DEVELOPMENT REVIEW BOARD APPLICATION

**RE: FINAL SIGN OFF OF EPC SITE PLAN
(PROPOSED 30 DWELLING DEVELOPMENT)
TRACTS 27A-1 AND 27A-2 OF TAYLOR RANCH, REDIVISION
OF TRACT 27A INTO TRACTS 27-A-1 AND 27-A-2 OF THE
PLAT OF TRACTS 27-A, S-1, S-2, AND S-3 TAYLOR RANCH,
SITUATED WITHIN SECTIONS 23, 25 AND 26 T11N R2E, BLOCK 0000,
LOCATED AT THE NORTHEASTERN CORNER OF THE
INTERSECTION OF MONTAÑO ROAD NW AND TAYLOR
RANCH ROAD NW (4701 MONTAÑO ROAD NW),
APPROXIMATELY 3.4 ACRES (E-11-Z AND E-12-Z)**

EPC CONDITIONS OF APPROVAL:

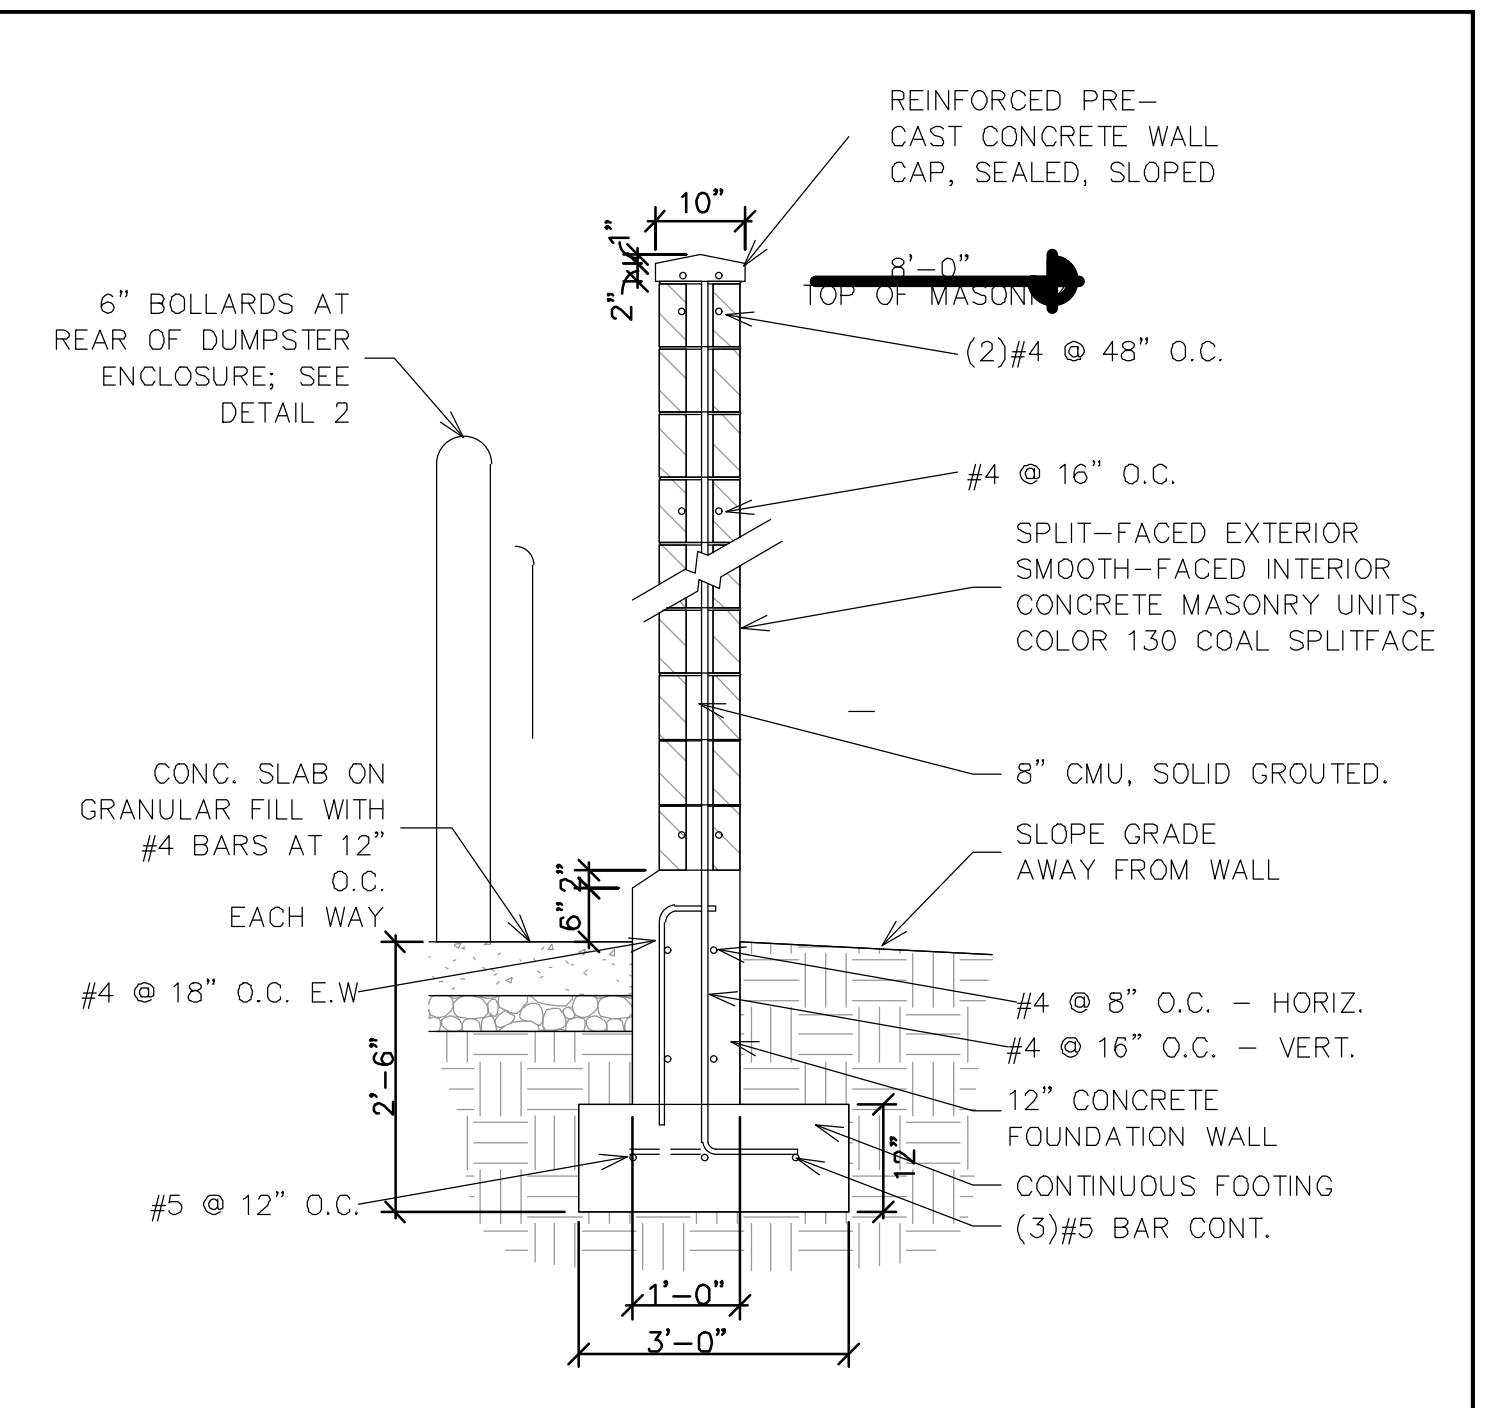
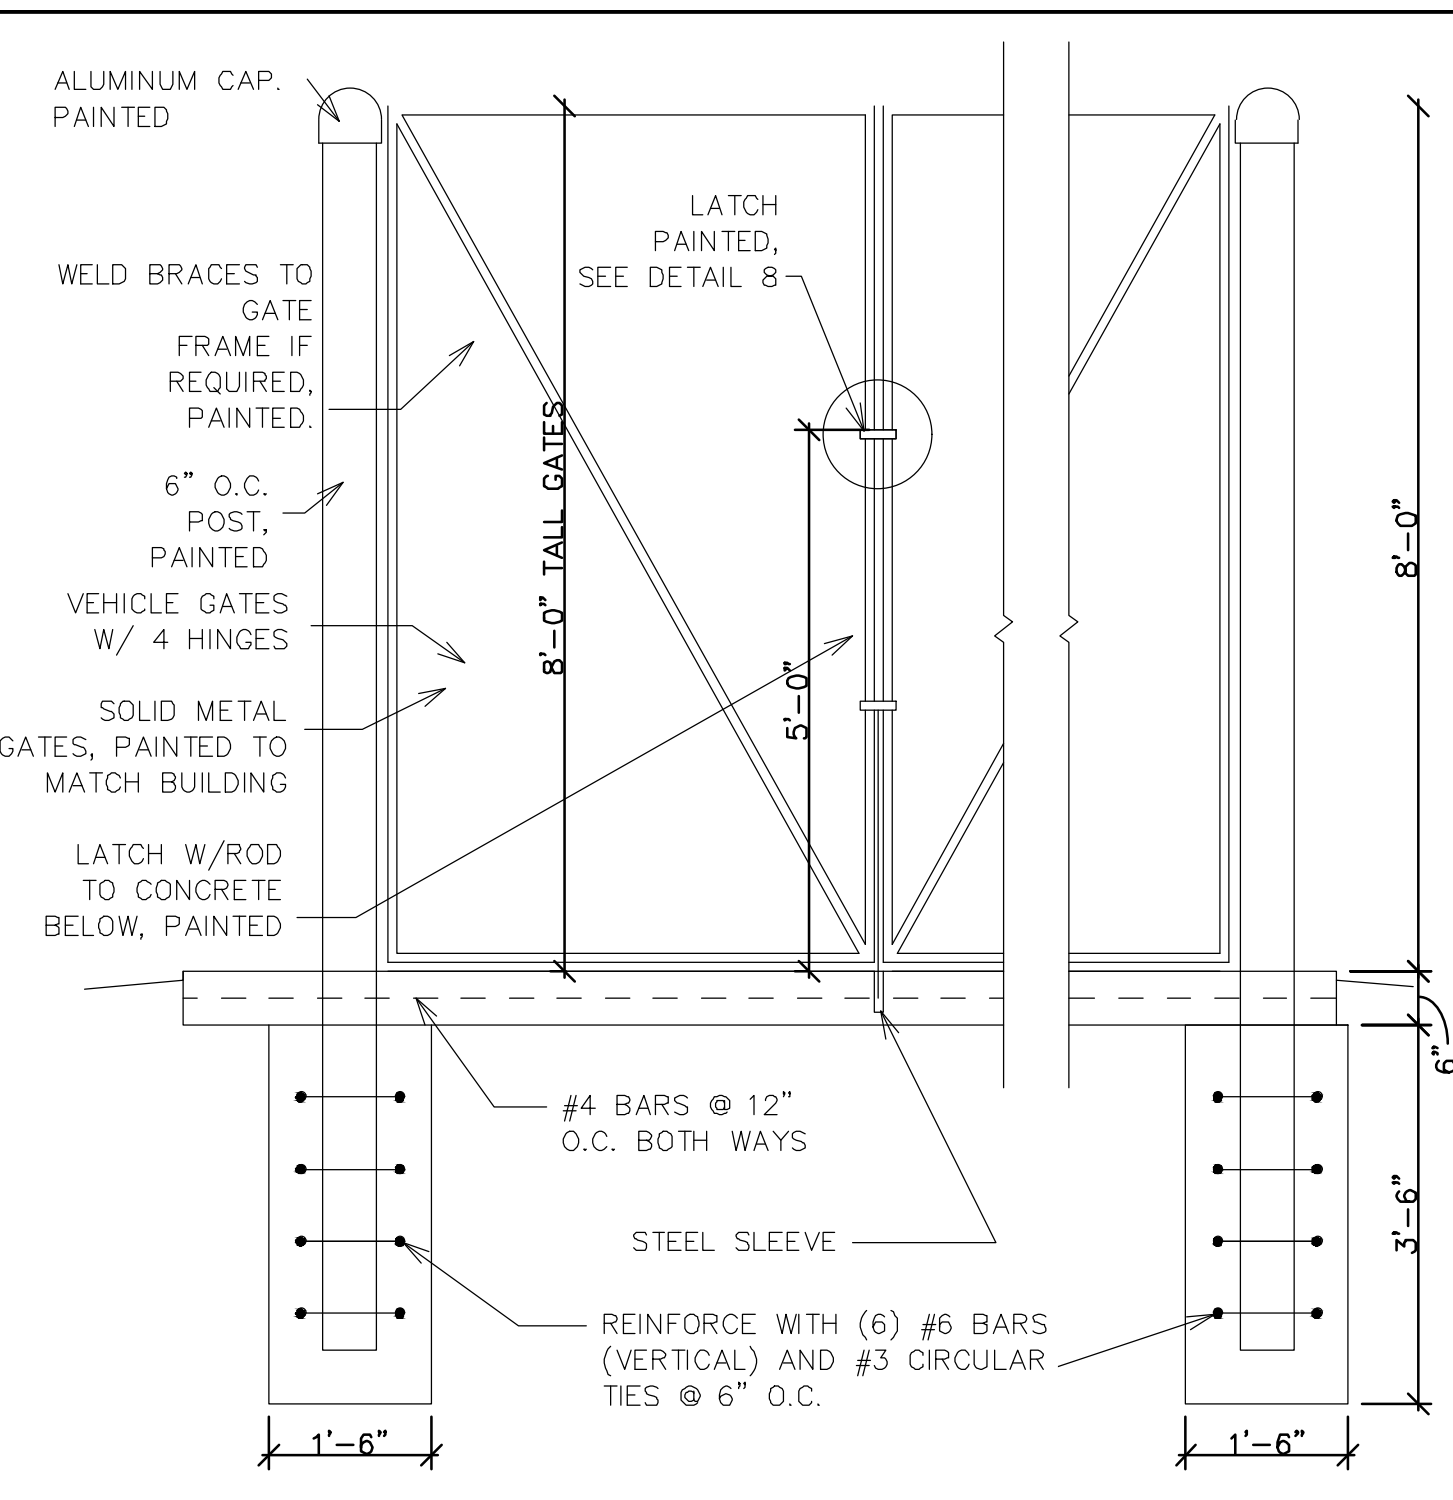
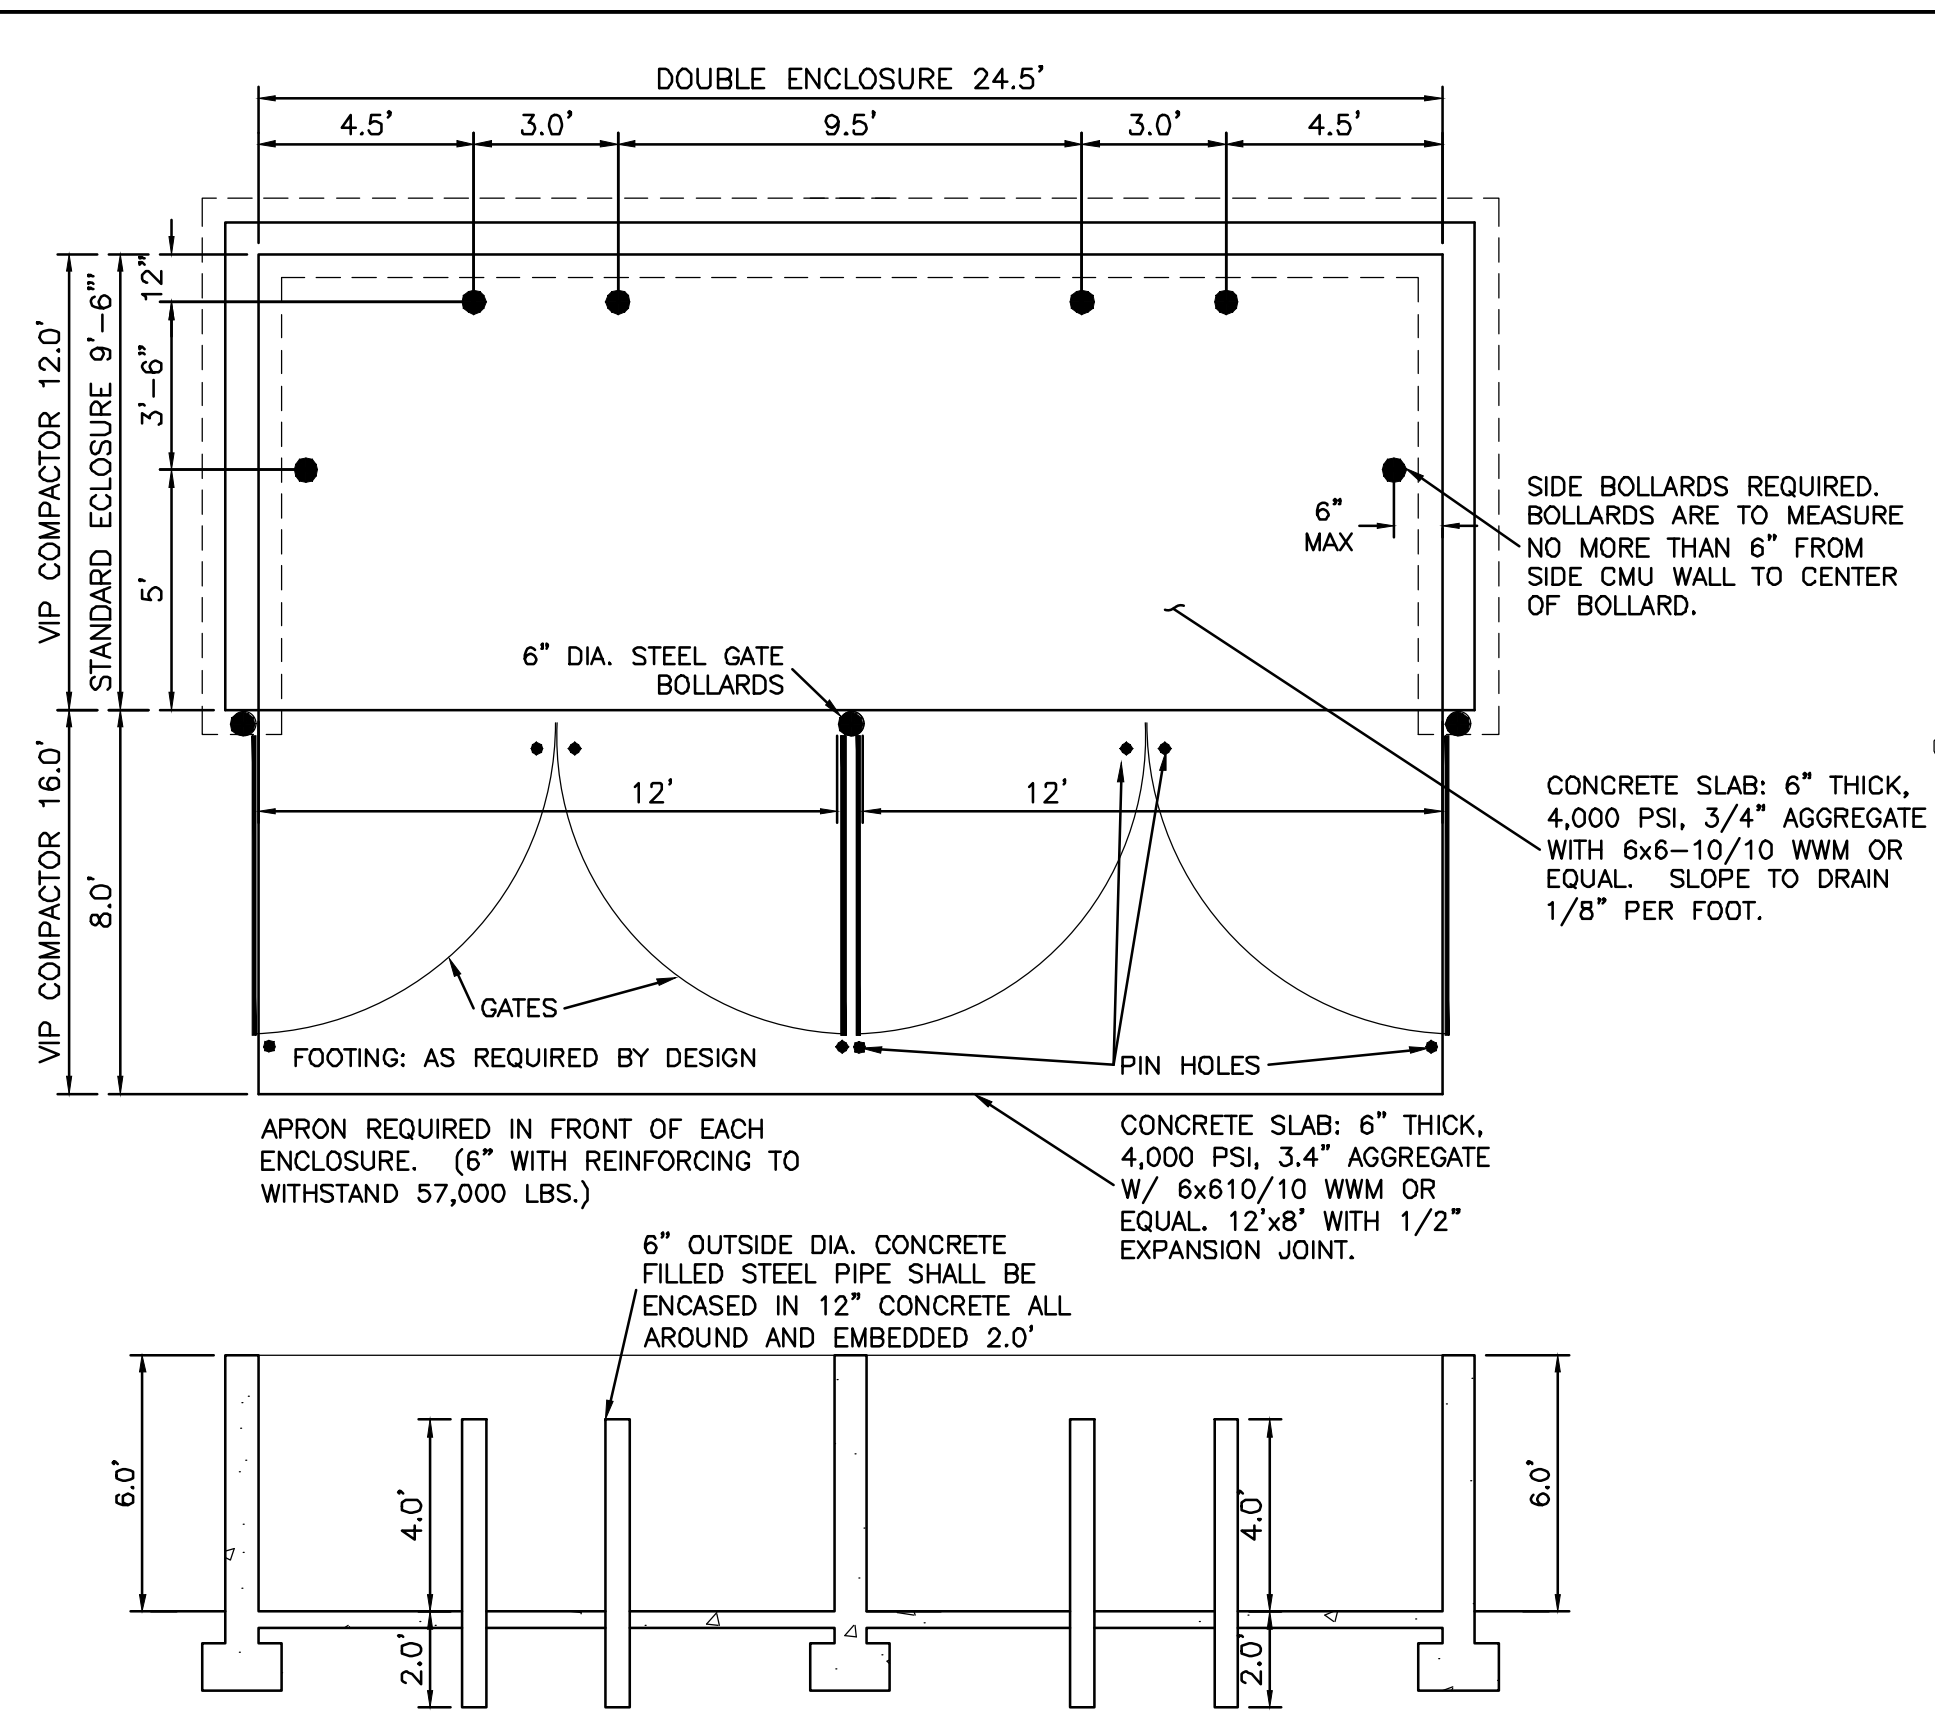
- I. Provide motorcycle and bike rack requirements. Provide details for these as necessary.
Bike rack detail Sheet C4. No MC parking provided.
